RZ-1.0

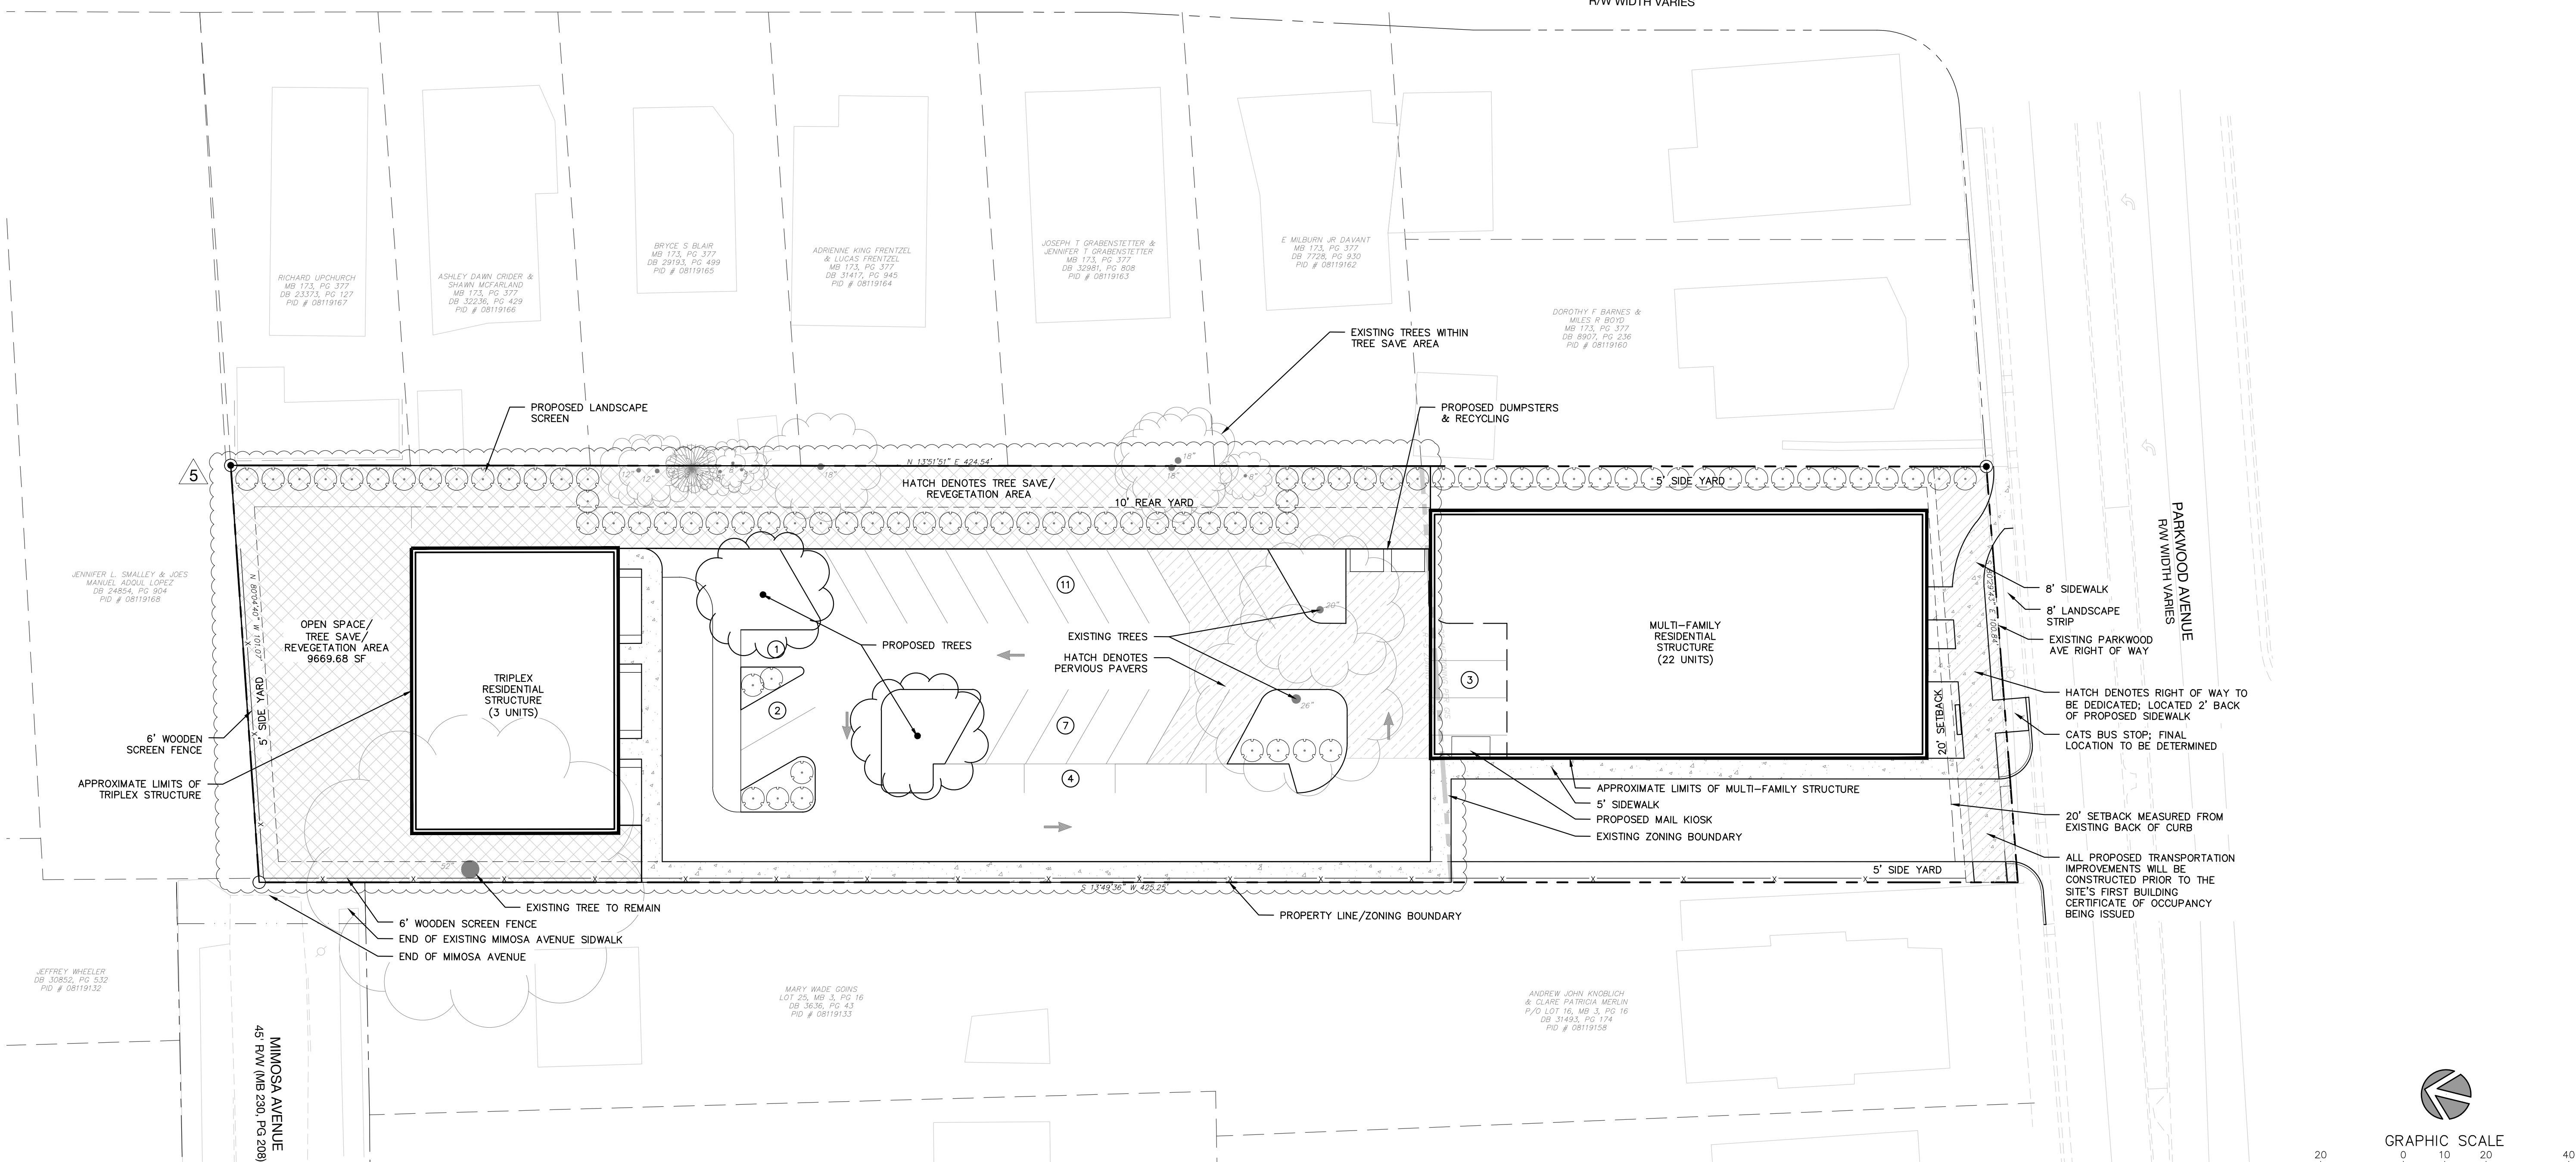
2019-179        1- Fire department access road shall have a min. 20' unobstructed clear width and shall be capable of supporting 80,000 lbs. This requirement hasn't been met. 2- Fire department access road that exceeds 150' shall provide an approved turnaround. This requirement hasn't been met. 3- Turn radius 30' inside and 42' outside. 4- Fire hydrant shall be located within 750' to the most remote point of building as truck travel for all buildings.
